MEMORANDUM

SUBJECT: VA256 - Gateway Trucking – Revised Variance of Use and Site Development Plan
RE: Transportation Memorandum and Road Conditions Report
Response to CDOT Comments Memorandum
LSC #S214361

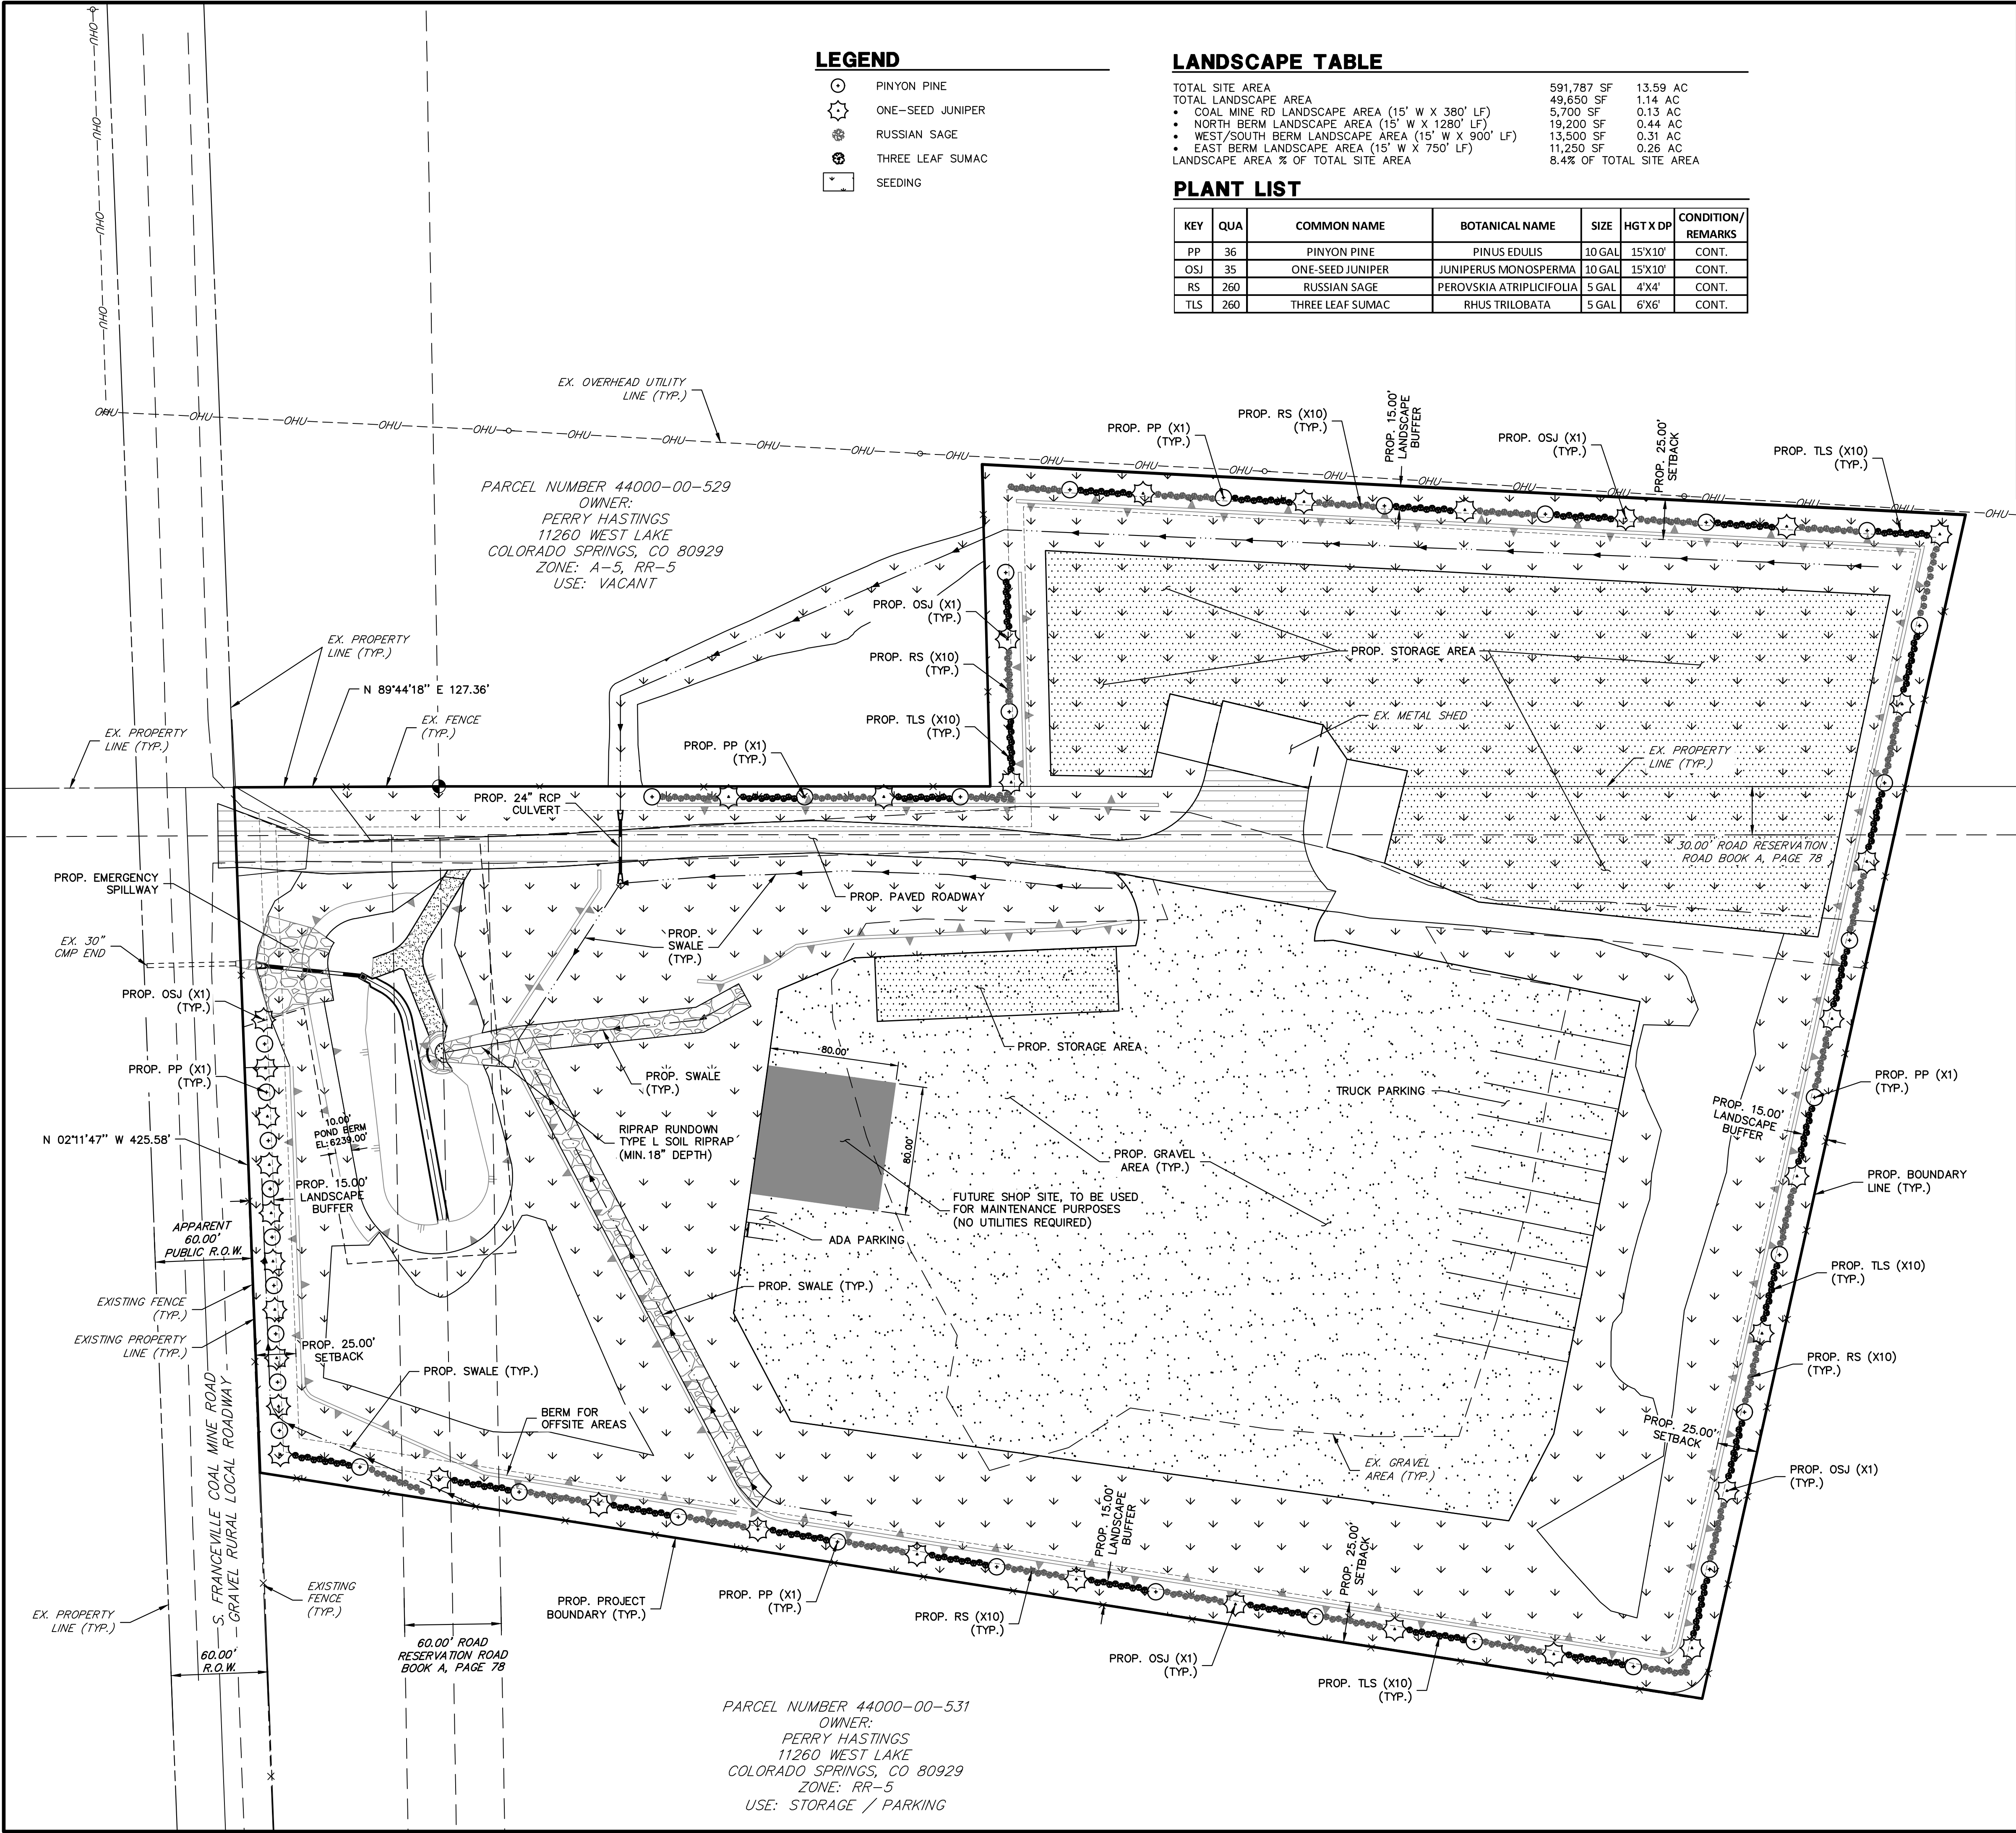
- c. *Radiuses of the access are required to be designed and built to allow use by multi-unit trucks without encroachment into other lanes of either roadway.*

- d. Paving of the access (Franceville Coal Mine Road) is required at a width of 36 feet south for a distance of 50 feet at a grade not to exceed 8%.*

LSC Response: Please refer to the updated TIS section **8.33 Other Improvements at the "Access"**.

LSC Response: Please refer to the updated TIS section **8.33 Other Improvements at the "Access"**.
